**Section 96A of the Town & Country Planning Act 1990 (as amended)
Town and Country Planning (Development Management Procedure) (England) Order 2015
(as amended) - Article 10**

Non material amendment following the grant of CM/48/21/RES to alter reference to detailed landscape plans under condition 1.

Land to the West of Church Lane and South of Horsemere Green Climping

DRAWING TITLE
Detailed Planting Plan
17 of 30

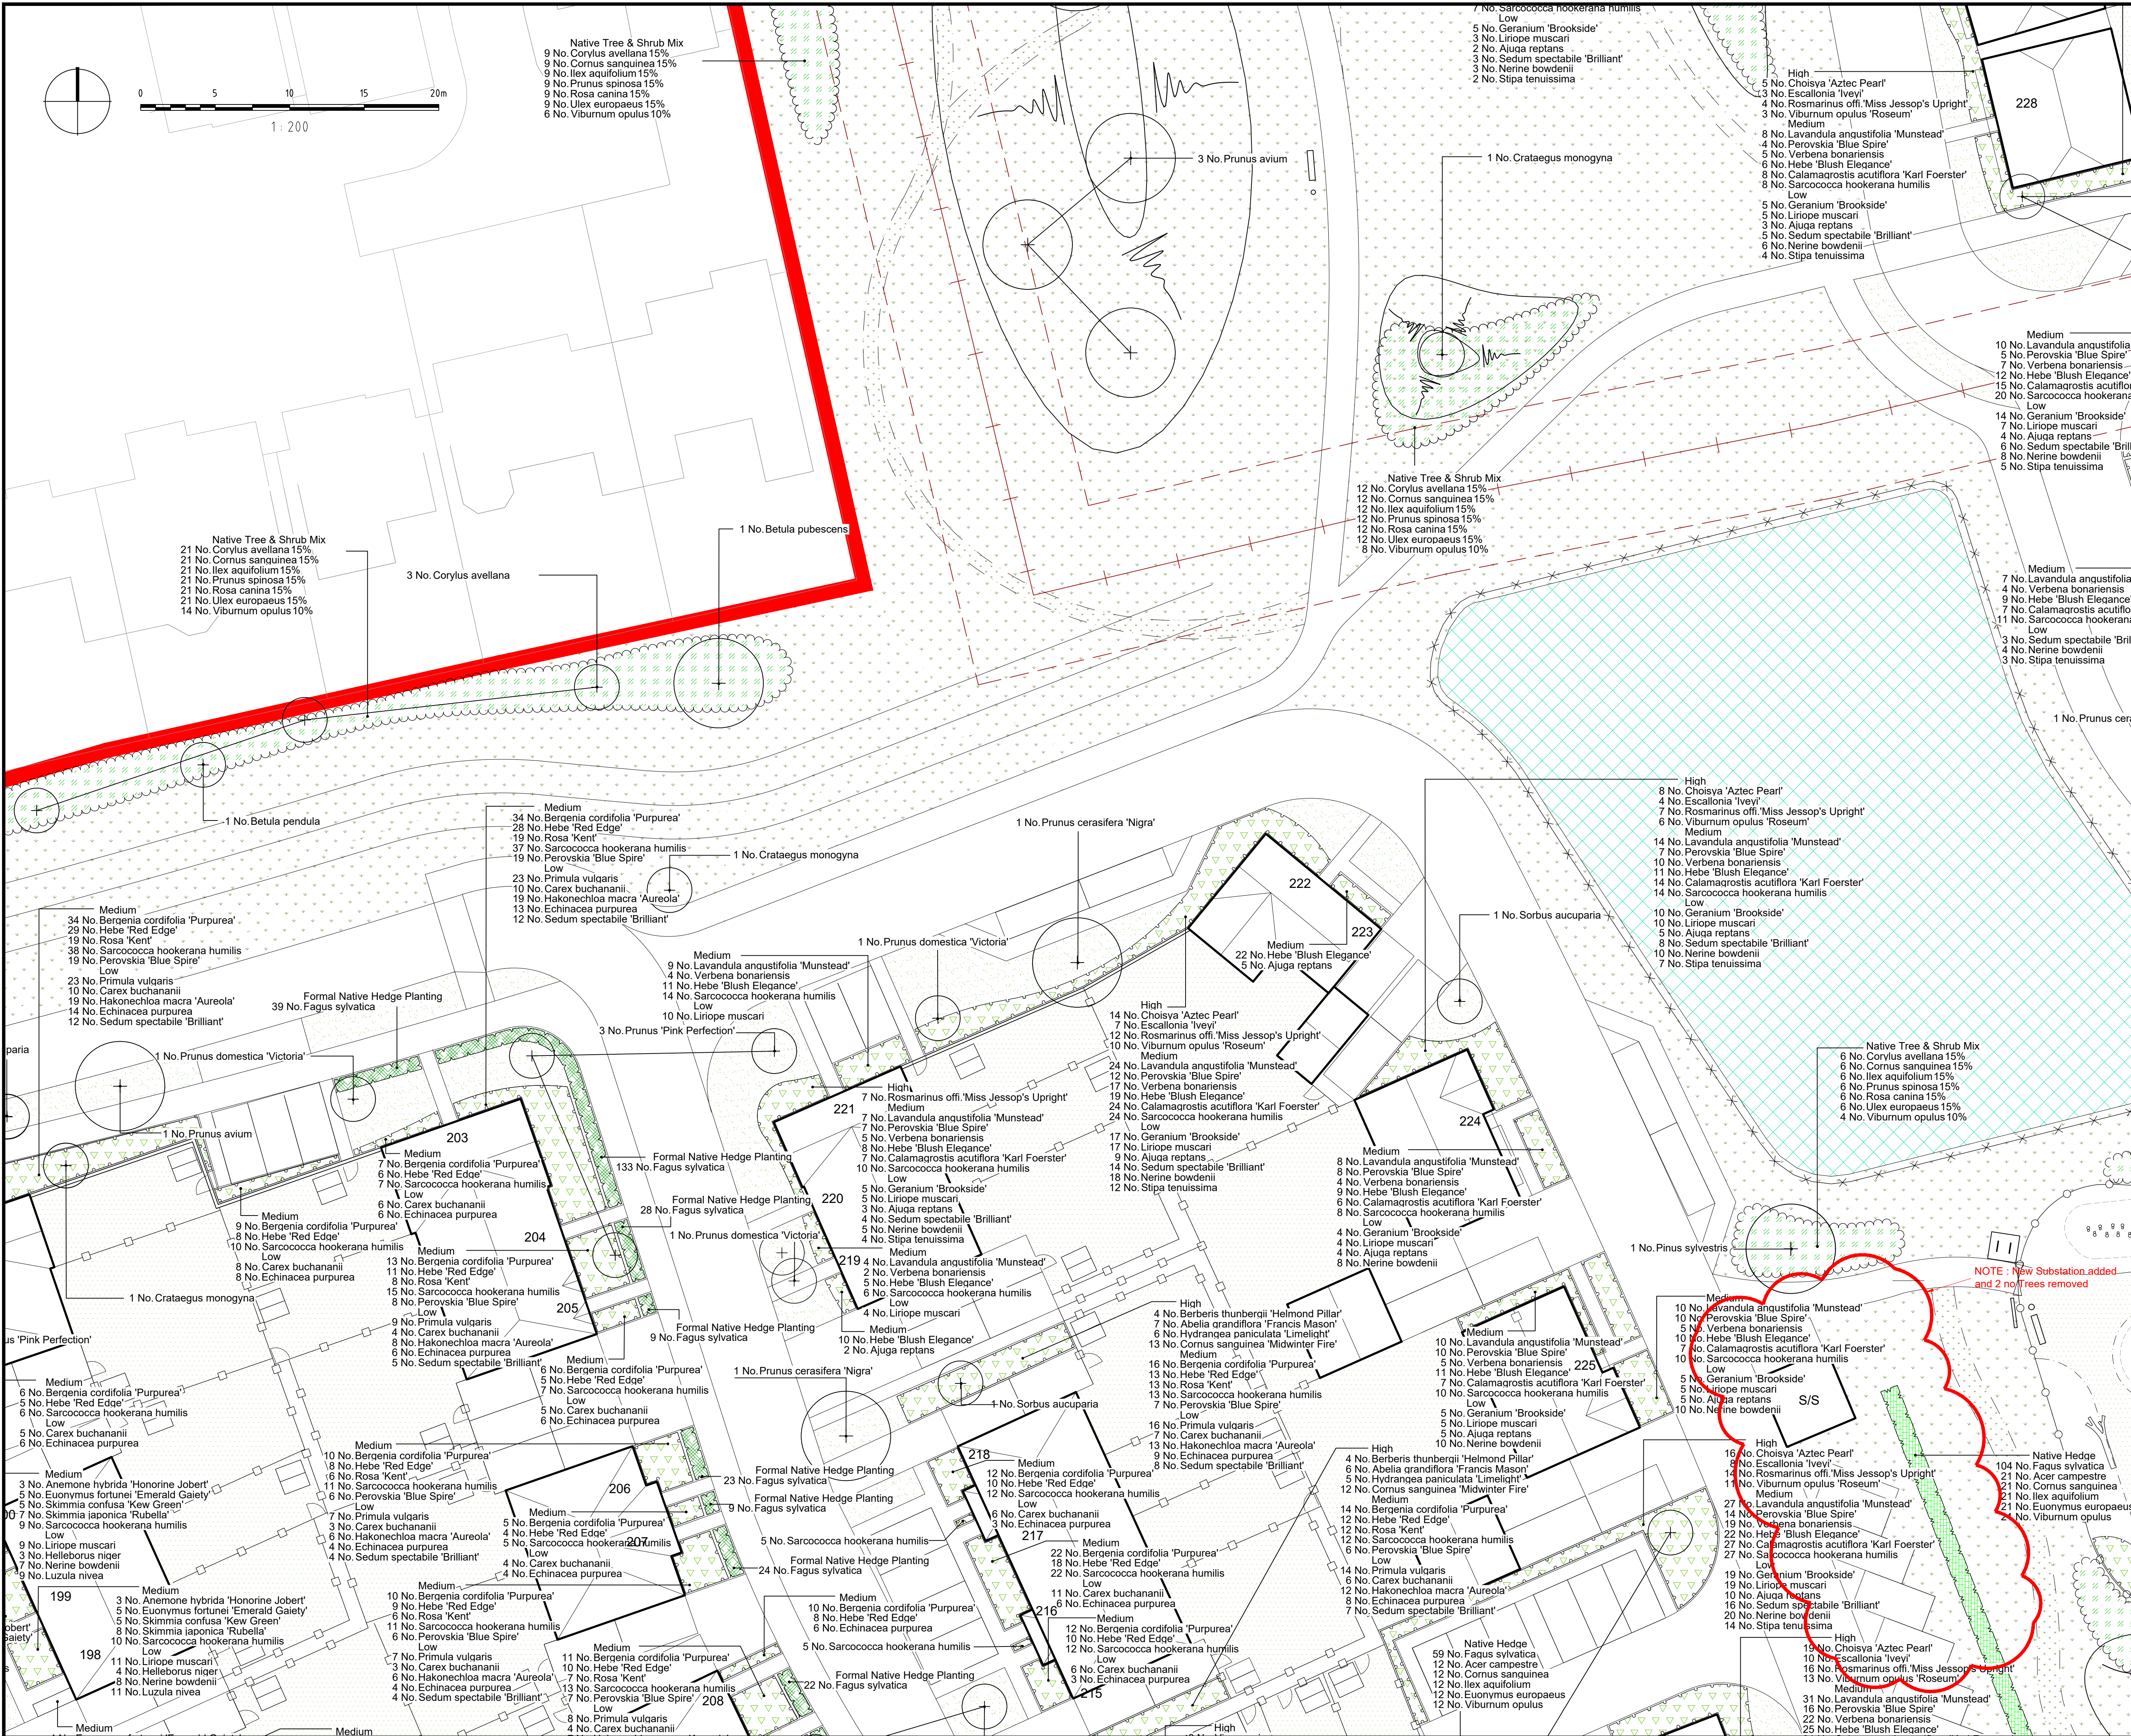
This application is seeking a Non-Material Amendment for revisions to the detailed planting plans approved by CM/48/21/RES under Condition 1 (Plans). These changes follow concerns raised in respect of the approved tree species, and their scale resulting in future issues to ground conditions and footings of existing properties to the north, and impacting their daylight. These trees have subsequently been replaced with smaller species which will have less impacts, both to the ground and shading, but still provide sufficient screening. The soft landscaping has also been amended to reflect the siting of a sub-station.

The changes to the detailed planting plans are acceptable. The proposed drawing revisions have been compared to the approved drawings and are clearly minor alterations that do not conflict with the above guidance or adversely affect the quality of the development as a whole. The changes to the proposed tree species, and minor change in the soft landscaping around the sub station will not result in material alterations to the appearance of the site, nor adversely impact the amenity of nearby occupiers. The changes can therefore be accepted as an NMA under section 96A of the Town and Country Planning Act 1990. The following plans and documents are therefore accepted as a non-material amendment:

DD406L12E Detailed Planting Plan 1 of 30
DD406L14E Detailed Planting Plan 3 of 30
DD406L18E Detailed Planting Plan 7 of 30
DD406L22E Detailed Planting Plan 11 of 30
DD406L28F Detailed Planting Plan 17 of 30
DD406L29E Detailed Planting Plan 18 of 30
DD406L34F Detailed Planting Plan 23 of 30
